Recommendation Report for Works to Tree(s) on trees subject to a Tree Preservation Order (

REF NO: FP/123/17/T

LOCATION: 16 Wellers Close
Felpham

PROPOSAL: 4m crown reduction & 2.5m reduction to bough of 1 No. Pine tree.

Additional photos for
16 Wellers Close BE
FP/123/17/T

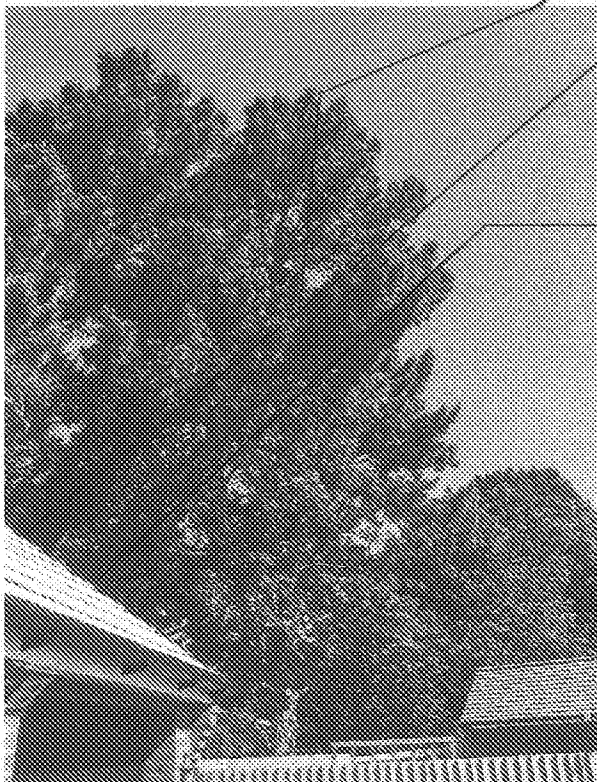
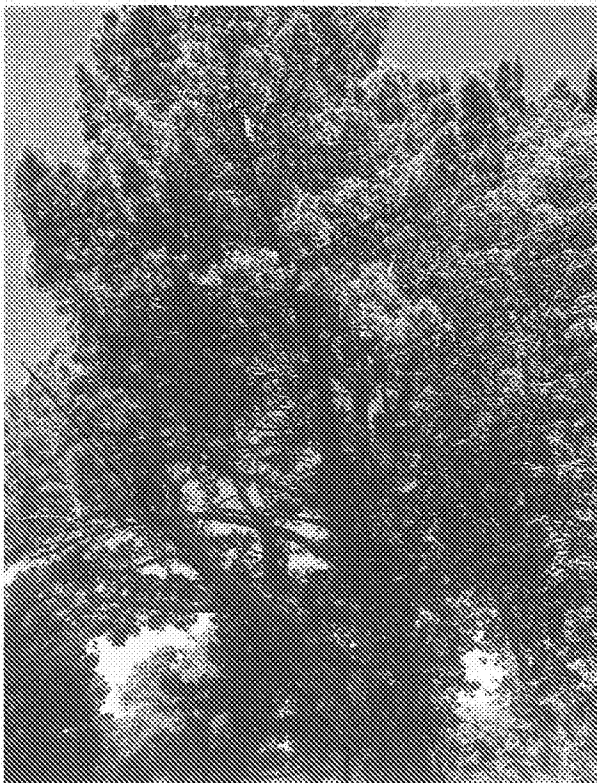
- A mature tree of significant proportions but development has been permitted too close to the tree and the inevitable 'pressure to prune' has arisen.

- It causes some shading in the late afternoon/evening and has heavy branch overhang of the garden with safety concerns ensuing.

- The proposal to reduce the length of several overhanging boughs by between 2.5m and 4m is reasonable to address the problems and inconvenience being suffered and will leave the tree in a safe condition.

- I recommend APPROVAL of this application subject to permission being obtained from the tree owner and also applying the following conditions: -

- Where whole branches are to be removed and final cuts made close to the trunk or branch union they are to be made as shown in Figure 2 of BS3998:2010
- Where branches are to be shortened back the final cuts are to be made at the correct angle shown in BS3998:2010 and adjacent to a live bud or lateral.
